Recommendation Report for Planning Permission for Works or Extension to a Dwelling

REF NO: P/29/19/HH

LOCATION: 53 Cardinals Drive
Pagham
PO21 4QD

PROPOSAL: Demolition of existing garage & outbuilding & erection of single storey side extensions (resubmission following P/87/18/HH).

sheet 1 a of 3

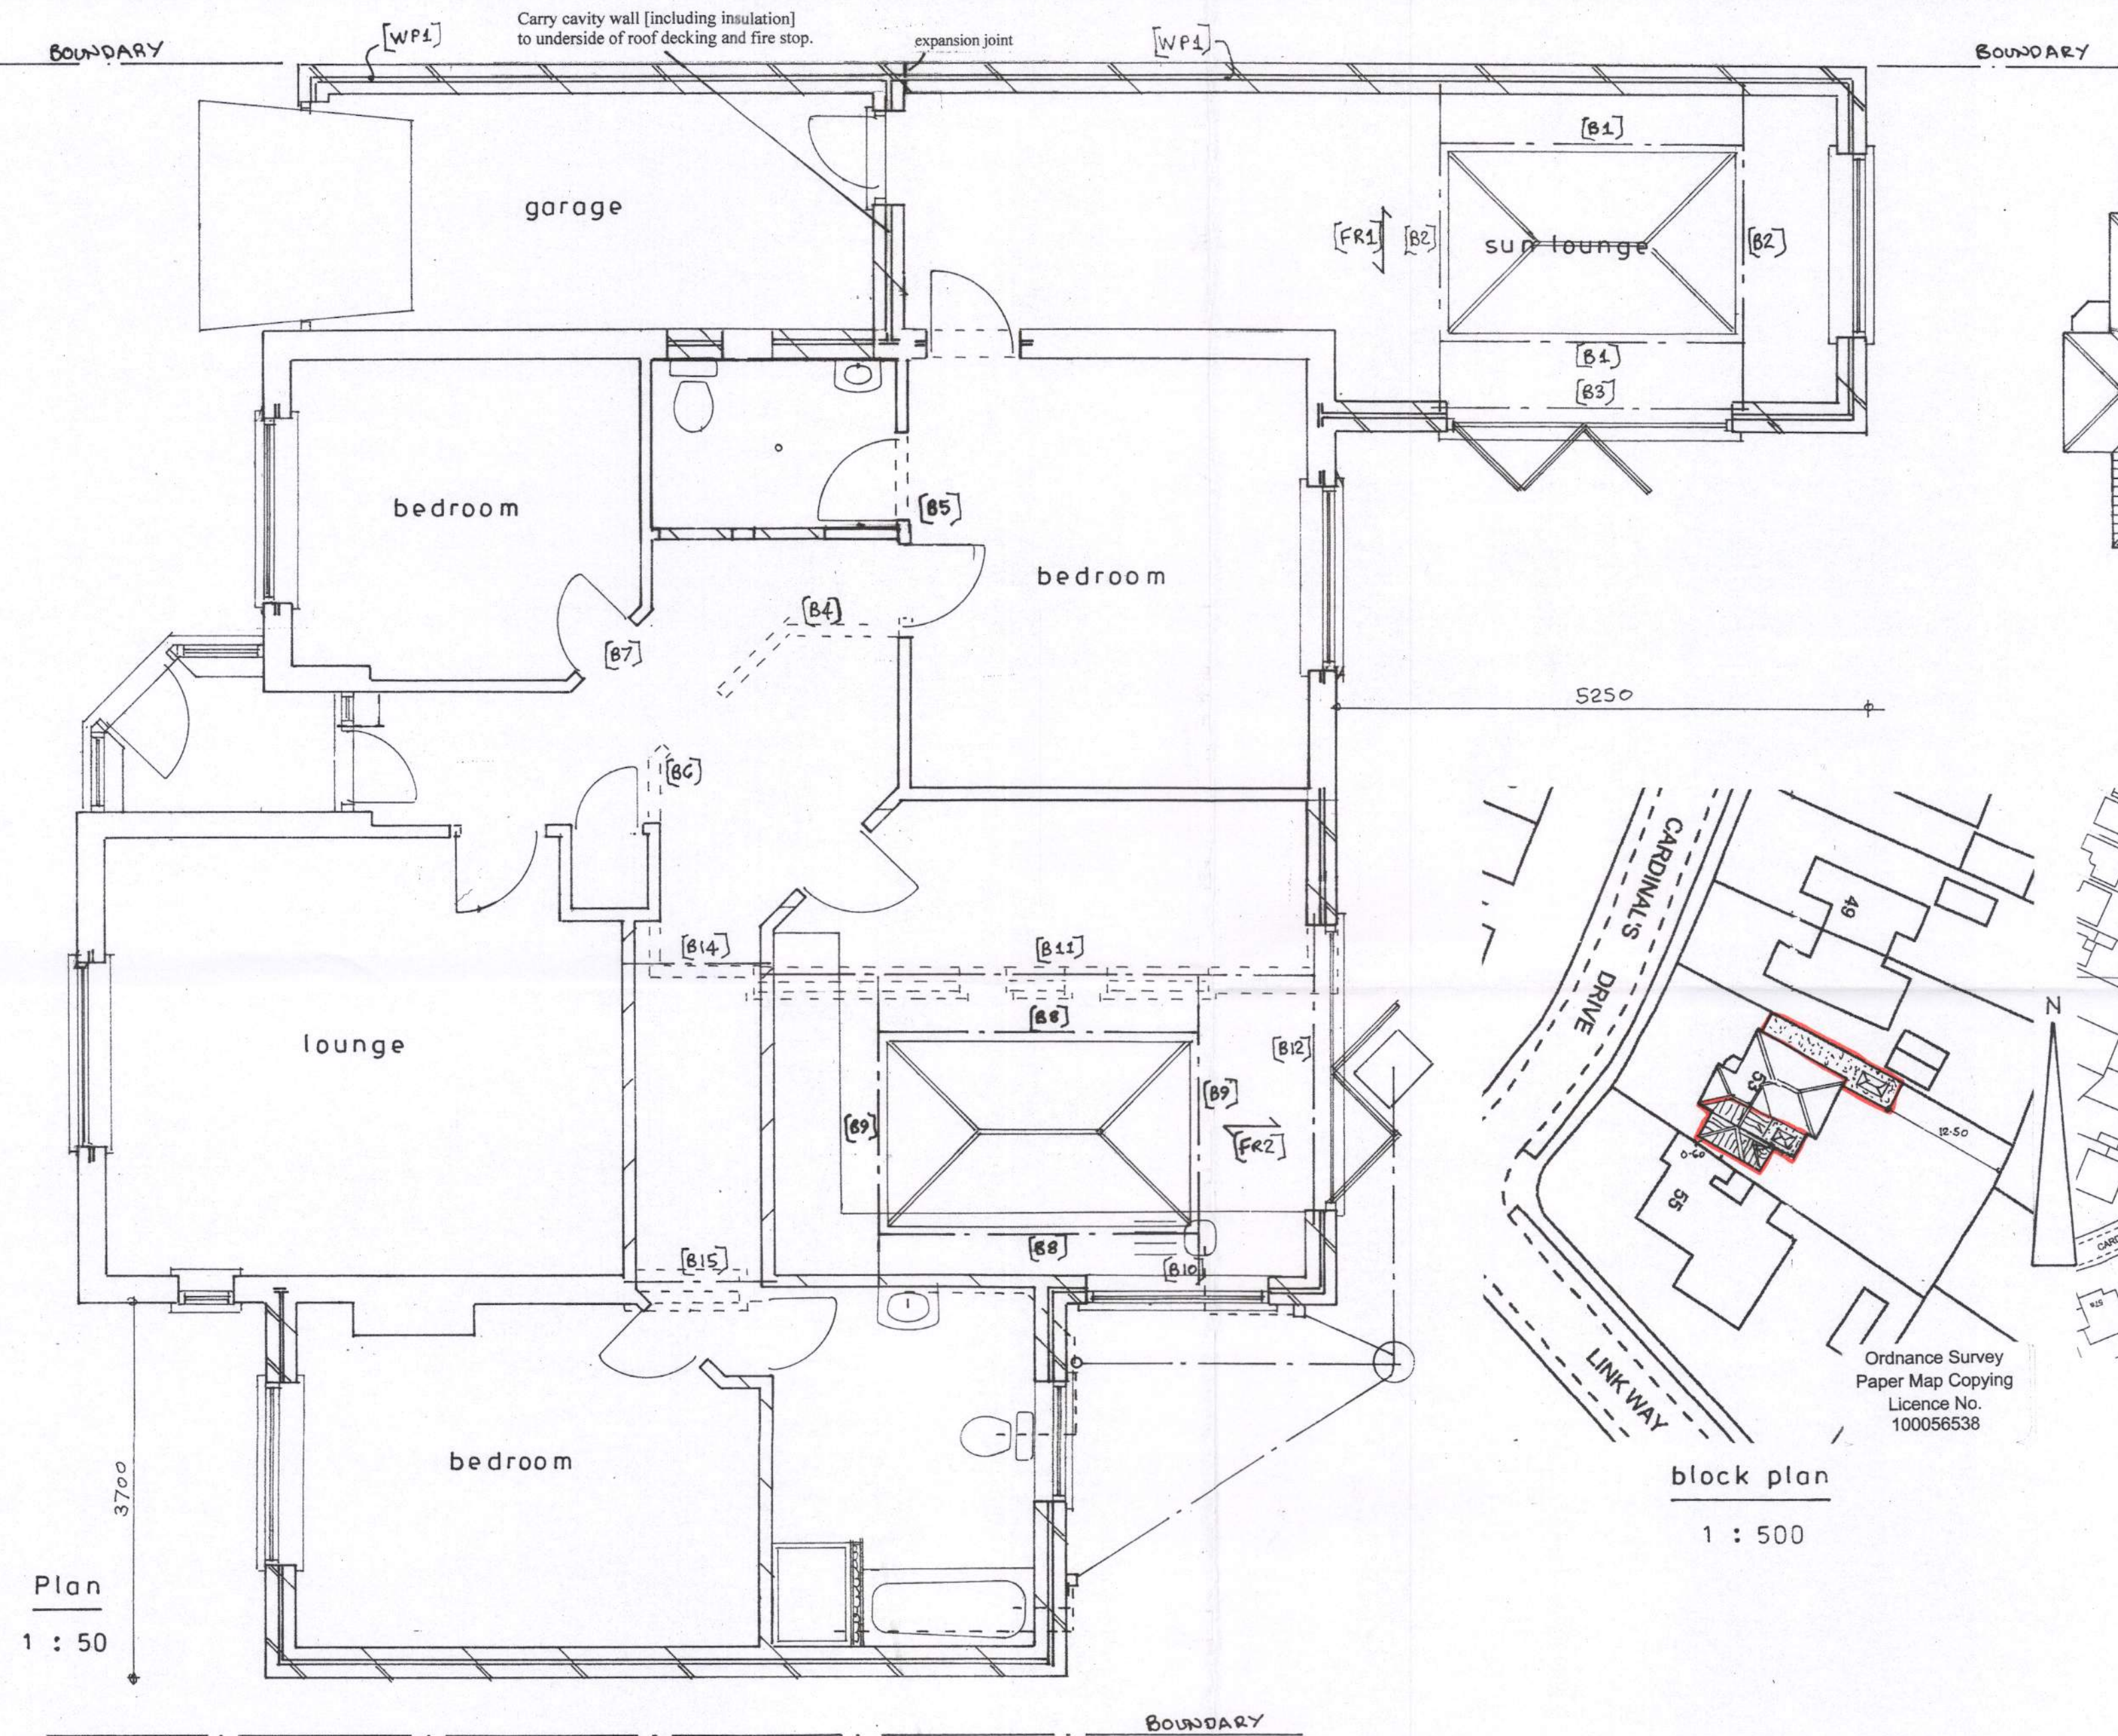
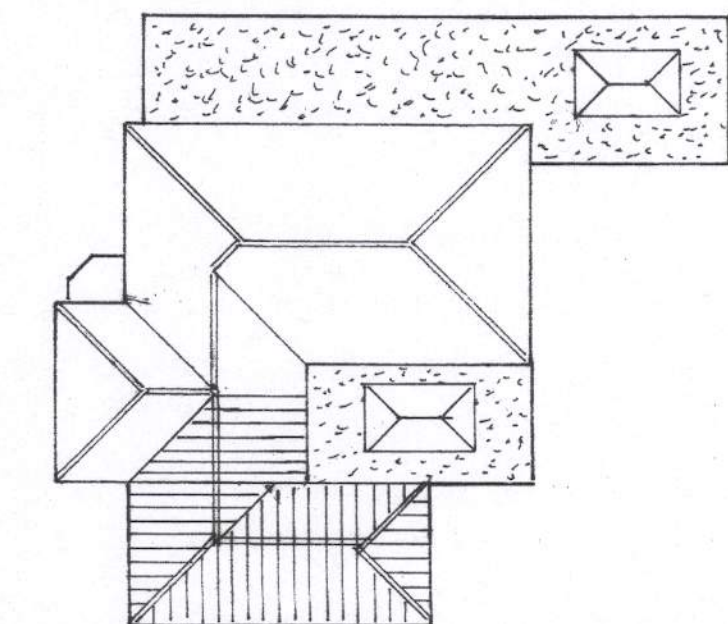
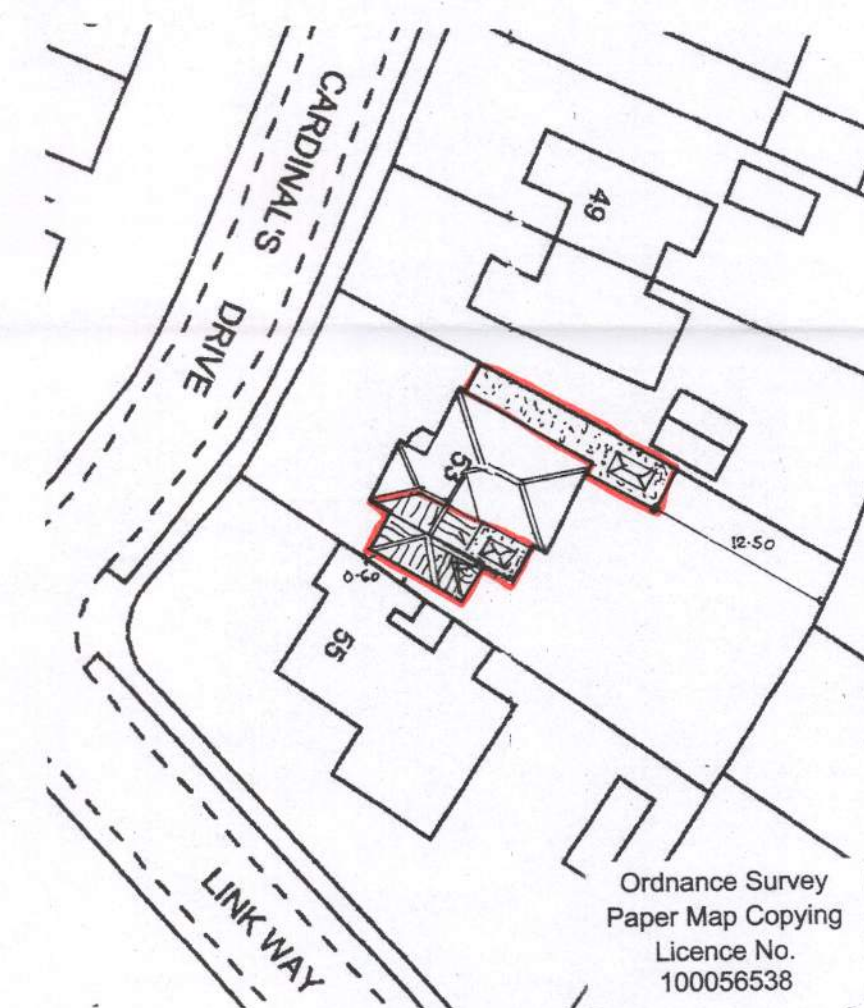
The existing small flat roofed south-western projection would be replaced with 3.7m wide and 7.9m deep side extension with a hipped end pitch roof matching the height of the existing. One large window is proposed on its front elevation and one smaller on the rear.

The garage would be replaced with a single storey side extension, 16m deep and 2.6m wide to the front and 3.6m to the rear, which would abut the shared boundary with No 51 to the north-east, incorporating 2.8m high flat roof with a lantern and a 0.3m high parapet wall above the flank wall. The proposed side extension would project from the rear elevation of the host building by 5.25m. Bi-folding doors would be inserted on its south-western elevation and French windows on the rear.

The existing flat roofed rear extension would be marginally deeper, aligning with the rear elevation of the original house and a new lantern would be inserted to its roof. The existing oriel window and glass door with side window on the rear elevation would be replaced with casement window and bi-folding doors.

sheet 2 a of 3

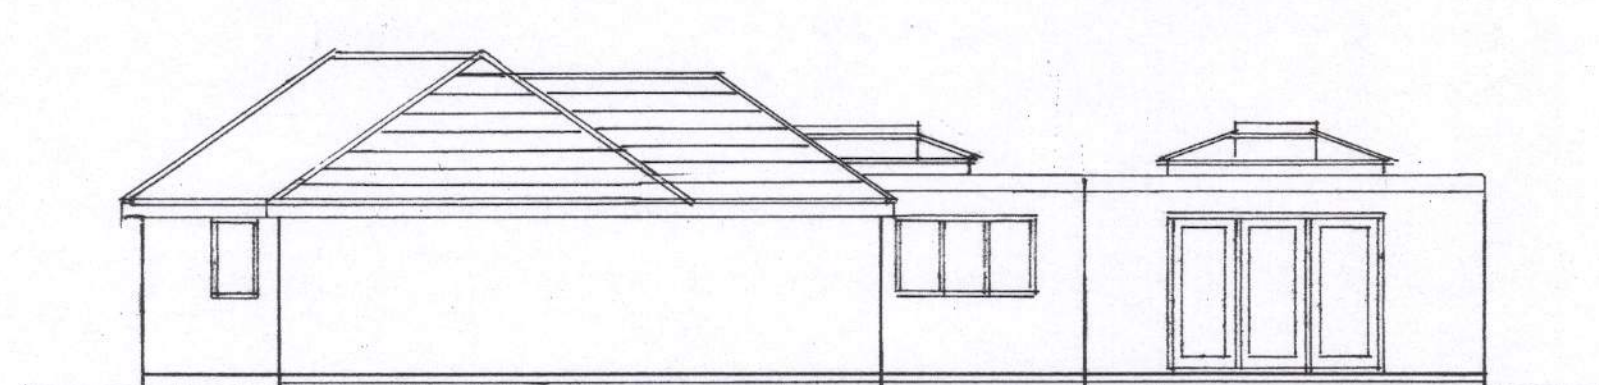
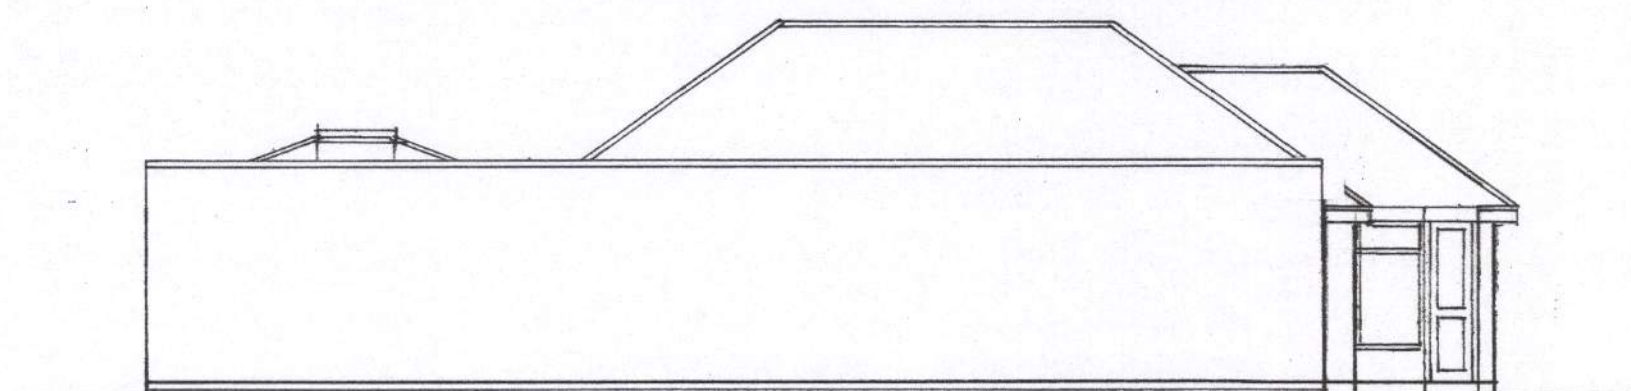
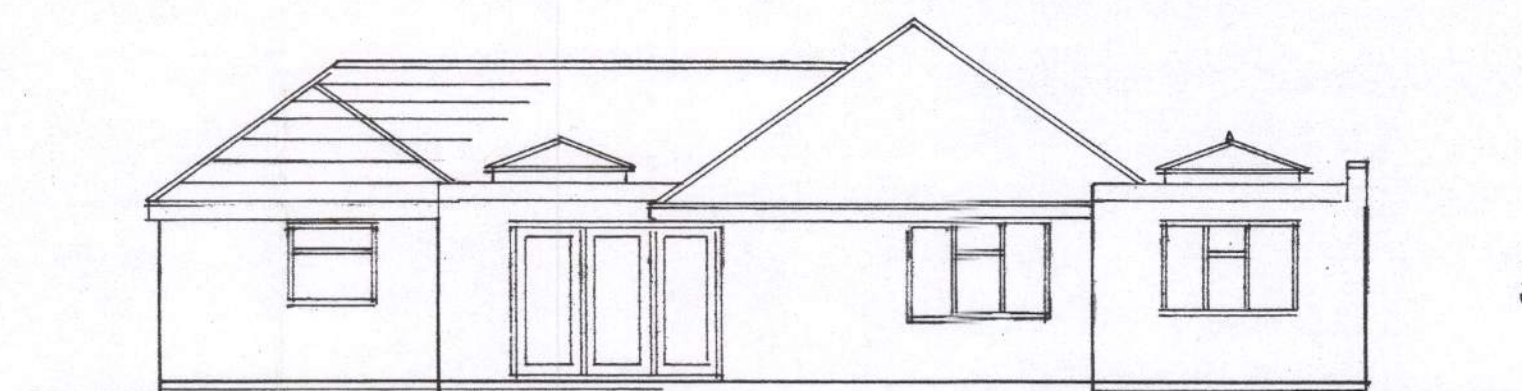
Prior to demolition, the garage and car port at 53 Cardinals drive was approximately the same height as 51 Cardinals drive which measures 2.4 meters (Ground to top of fascia board).

At 51 Cardinals drive, the main entrance to the bungalow along with windows from the lounge (side aspect), the bathroom, the kitchen and the conservatory (side aspect) all directly face the north boundary wall of number 53 Cardinals drive. Where we previously had open views of the skyline, surrounding roof tops and tree tops it is now completely dominated by a very high wall that quite frankly looks like a commercial building.

The new wall is very overbearing and overshadowing and is not in keeping with the surrounding buildings or indeed Pagham. I can't understand why it has been designed and built so high, the garage door is only 2.1m high so why does the building need to be so much higher than it was before.

The difference between approved application P/87/18/HH and recent application is the proposed 0.3m high parapet wall above the flank elevation of the proposed north-eastern extension.

The garage along the northern boundary will also increase in depth and width resulting in a 16m long wall abutting the shared boundary with No 51 to the north-east. The height of the flank wall would be extended by 0.3m, the height of the parapet recently proposed. As such the wall on the shared boundary would be 3.1m high (a roof lantern with a maximum height of 3.5m). However, given the separation distance of approximately 3m from the flank wall of No51 and the position of the proposal partially shielded by the existing garage of No51, it is not considered to give rise to any overbearing or overshadowing upon the neighbouring amenity.

Noted. There are amendments to the approved application. It is not considered that the differences between the approved and existing plans result in any reasons to justify a refusal.
